MMC CT Condition #7, #9 & #10

Tue, Jun 9, 2020 at 1:28 PM

Drawing file: originals / Pedstrian Easement Exhibit A 2020 0515.pdf

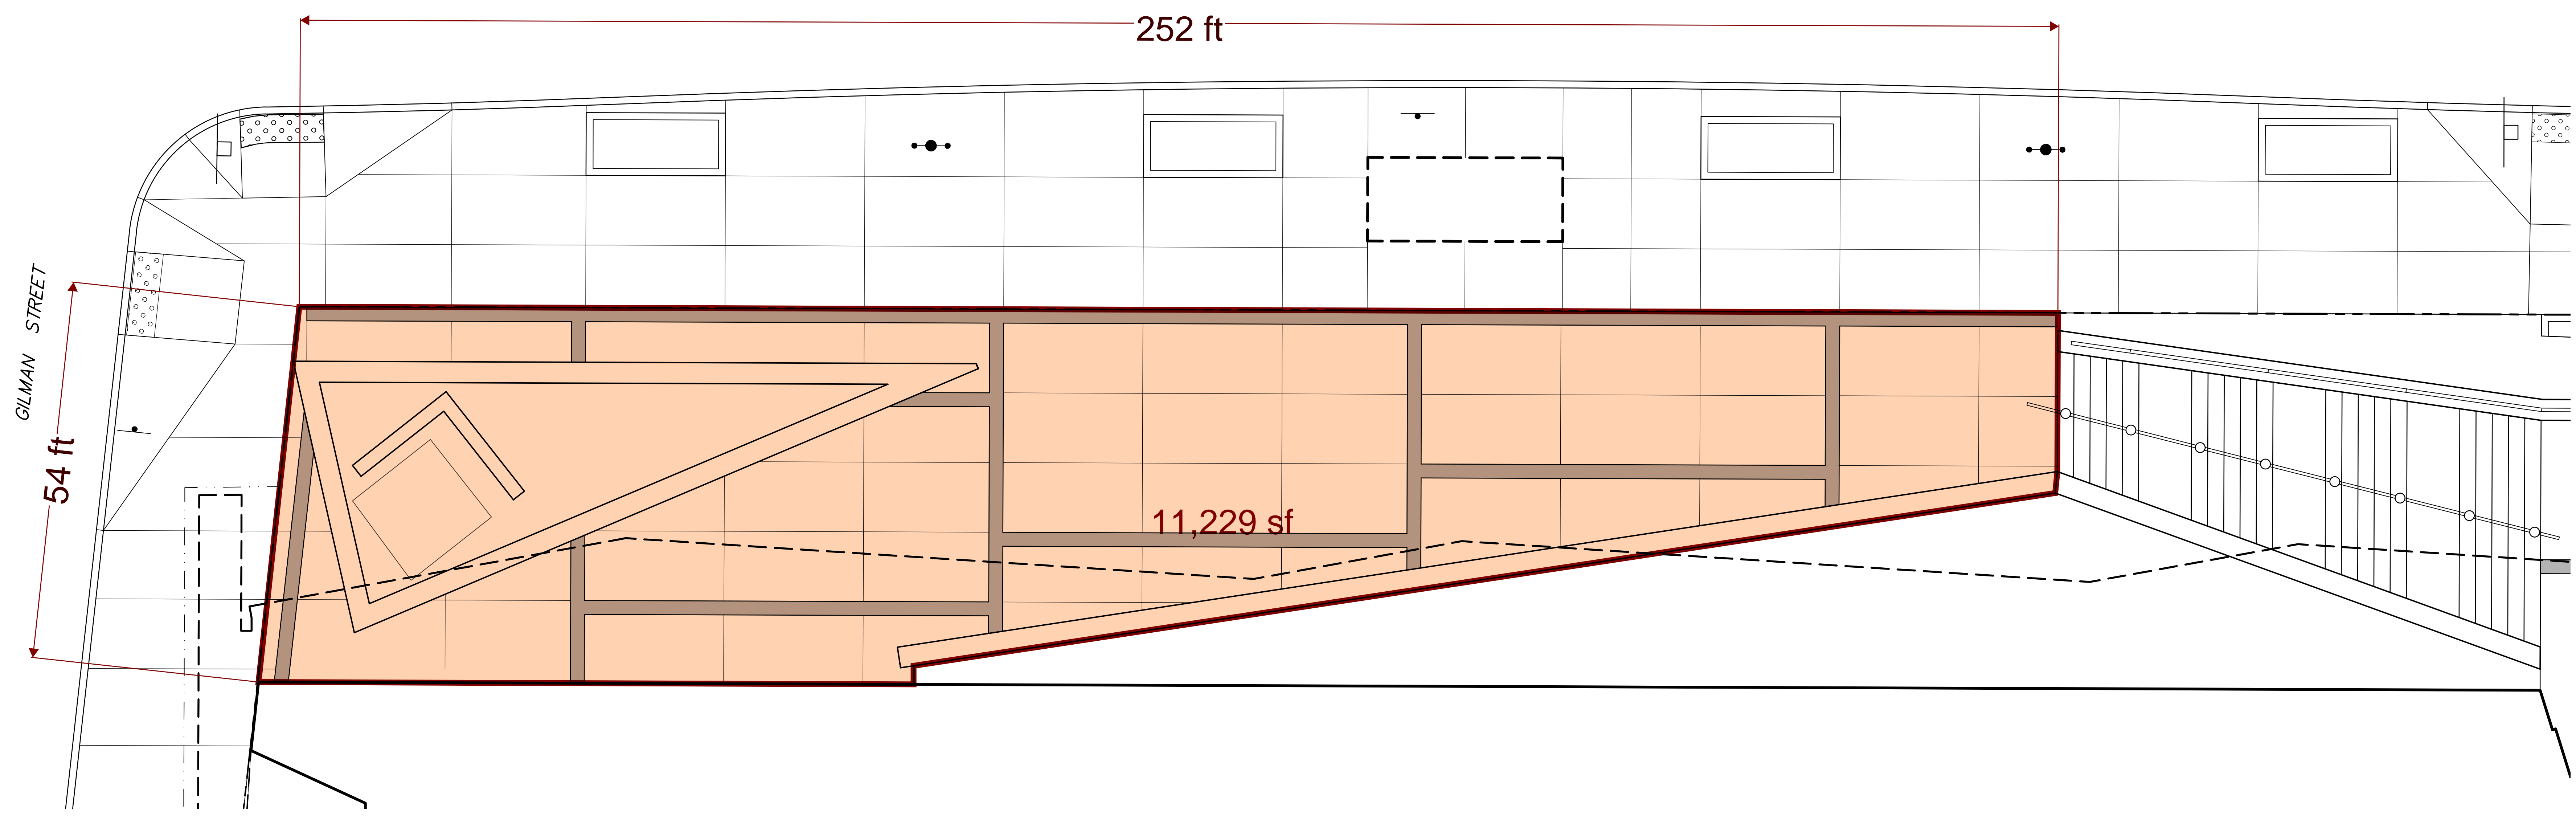
With regard to the exhibits, I'm not really sure which exhibit goes with which license agreement. I assume that the one labeled "Pedestrian Easement" goes with that document.

None of these exhibits are detailed enough with regard to the dimensions of what is being conveyed and agreed to. These exhibits should show bearings and distances for all of the boundaries of these licenses and easements. They should also show the existing street right-of-way lines more clearly so it's easier to see what's being conveyed on either side of the limits of the public way. I would suggest that a surveyor be involved in preparing the exhibit plans.
